Town & Country Planning Act 1990 (as amended)
Town and Country Planning (Development Management Procedure) (England) Order 2015
Application for approval of details reserved by condition imposed under AL/51/17/PL relating to
conditions 3-surface water drainage, 5-site set up during construction, 6-schedule of materials &
finishes, 7-details of new screen fence, 8-dustbin enclosure details & 10-covered & secure cycle
parking.
Woodgate Farm Westergate Street, Westergate,

Notification regarding the above application:

Condition Number 10

FENCE LOCATIONS
2016/36 / SK-2

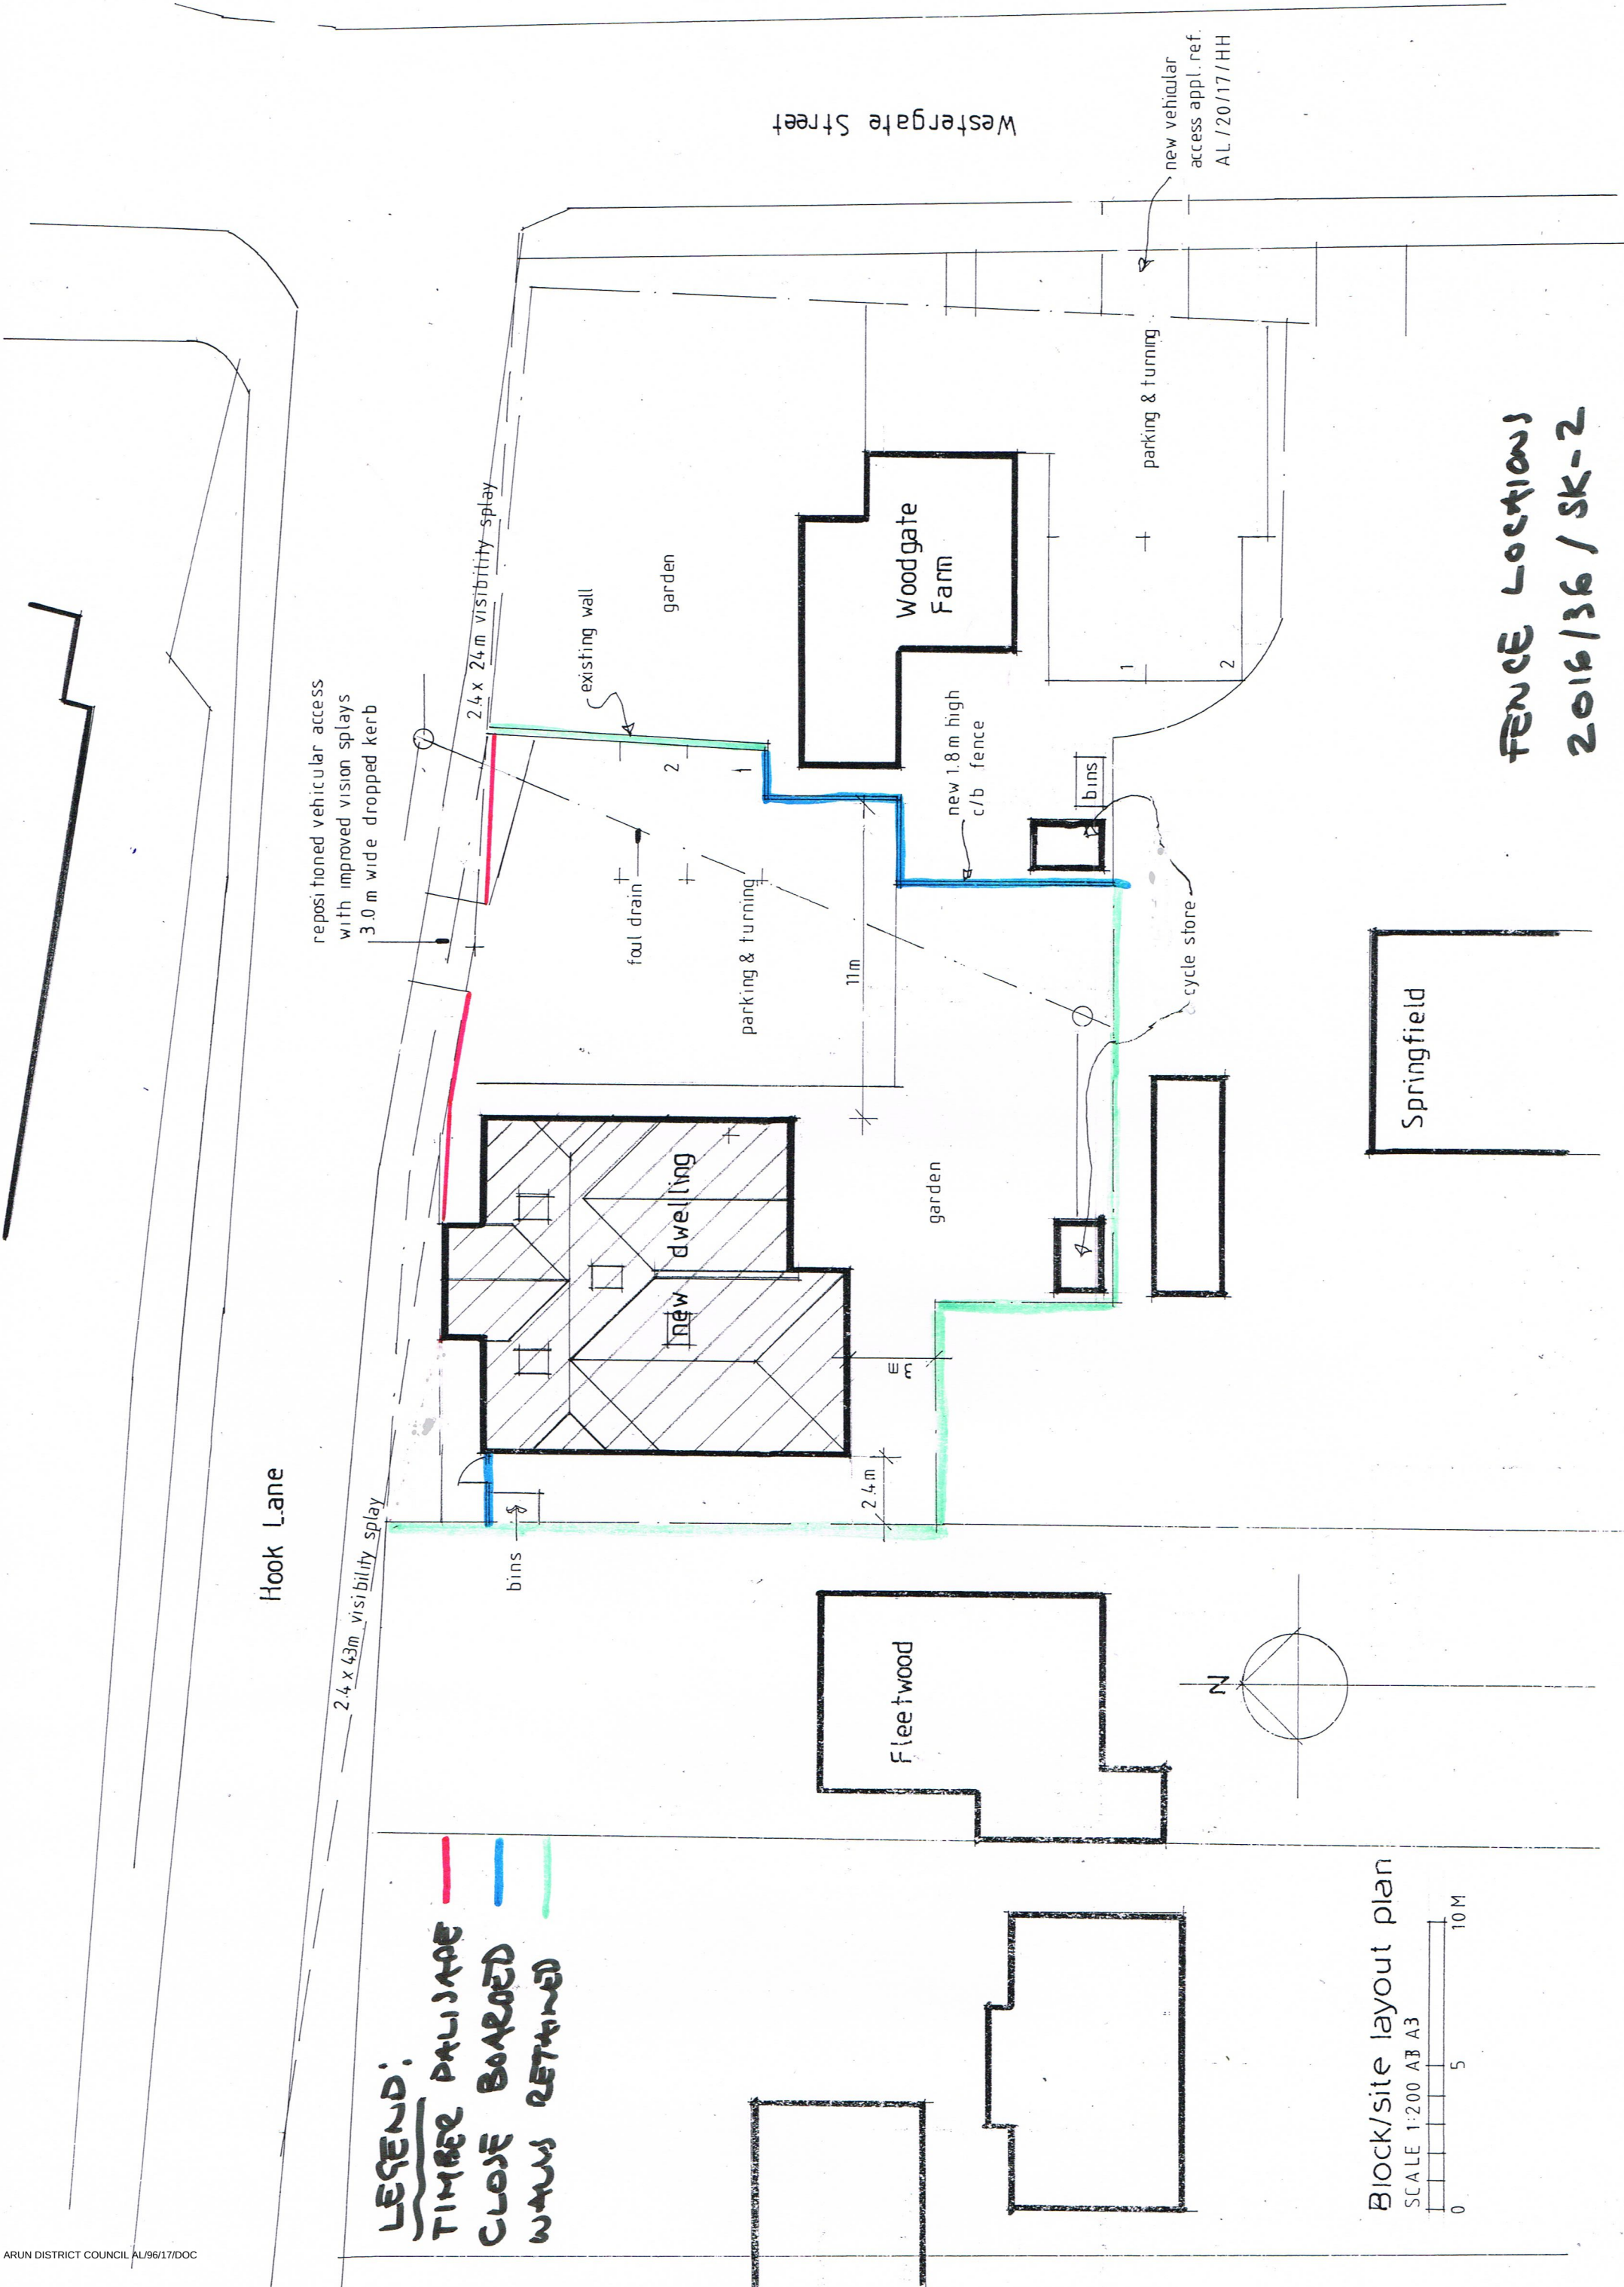
The submitted details in respect of secure cycle storage namely the location of two garden shed & cycle stores as shown on Drawing 2016/36/SK2 "Fence Locations" and the elevations of these stores as shown on Drawing SK-5 "Cycle Store" are considered to provide an acceptable scheme and satisfy the requirements of the condition.

The condition is therefore fully discharged insofar as the submission of details relates and on the understanding that the two cycle stores will be provided in accordance with the agreed details and thereafter permanently retained.
